**City of Portland, Maine**  
**Inspections Division**  
**Violations Report**

Dist. #	Sch. Date Contact:	CBL	Appl. Type Inspector	Schedule Type Comments	Appl #	Location
	06/11/2015 Thomas Reed House Llc	046 C001001	Fire Prevention David Petruccelli	FP Routine Inspection Inspections from Naviline Fire Inspections		0030 DEERING ST

Dist. #	Sch. Date Contact:	CBL	Appl. Type Inspector	Schedule Type Comments	Appl #	Location
2	03/07/2016	046 C001001	Fire Company Michael Nixon	FP Routine Inspection		30 DEERING ST

BASEMENT

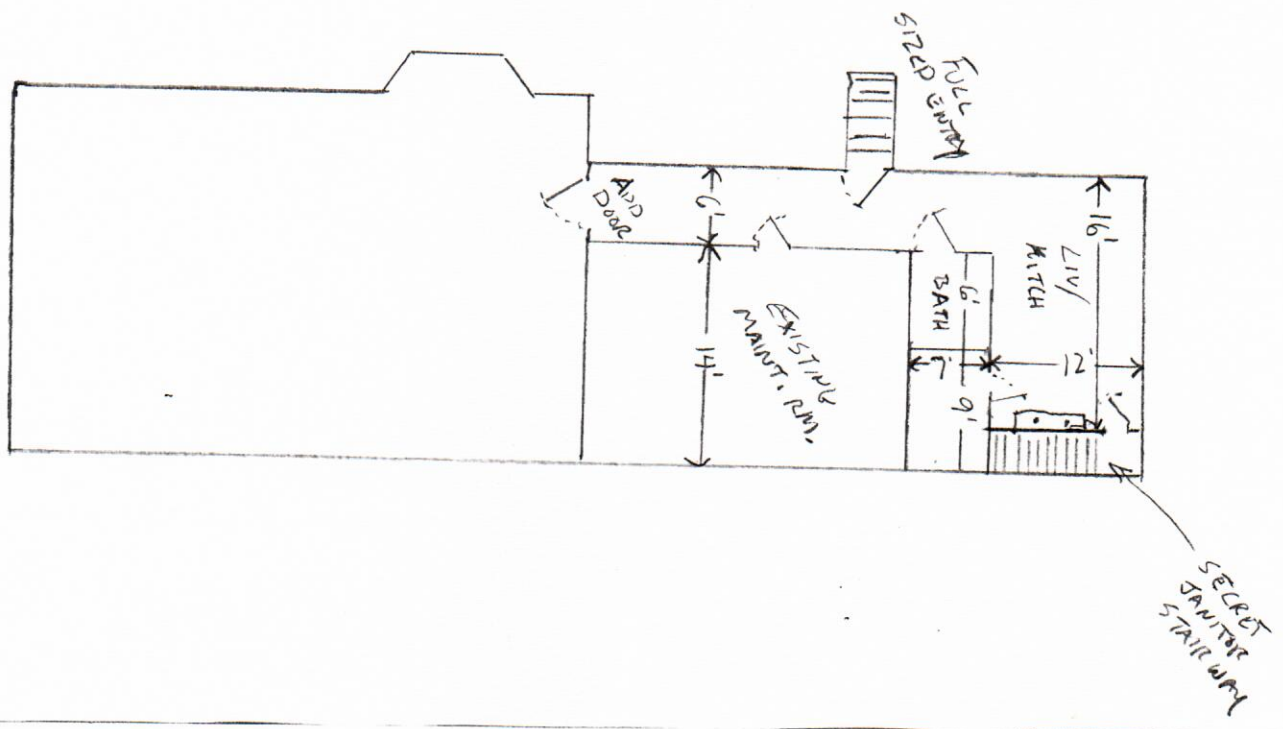
Code	Violation	Status	IntExt	Floor	Area	Corrected	Date
NFPA 101- 7.2.1.15.8- 73 05	Fire Door Assembly Req Repair One furnance room has a fire door that needs a self closer	Open				<input type="checkbox"/>	
NFPA 10- 7.2.4.4- 81 20	Fire Extinguisher Inspection Tag In the basement(some)	Open				<input type="checkbox"/>	
NFPA 101- 9.7.4.1- 81 30	Fire Extinguishers Req- Other Extinguishers need to be mounted (in several areas)	Open				<input type="checkbox"/>	
NFPA 101- 31.3.4.5.1- 55 25	Smoke Alarms Required Detector 110 is damaged	Open				<input type="checkbox"/>	
NFPA 101- 8.3.4.2- 80 37	60 Minute Fire Door Required Throughout... One furnance room has a hollowcore door	Open				<input type="checkbox"/>
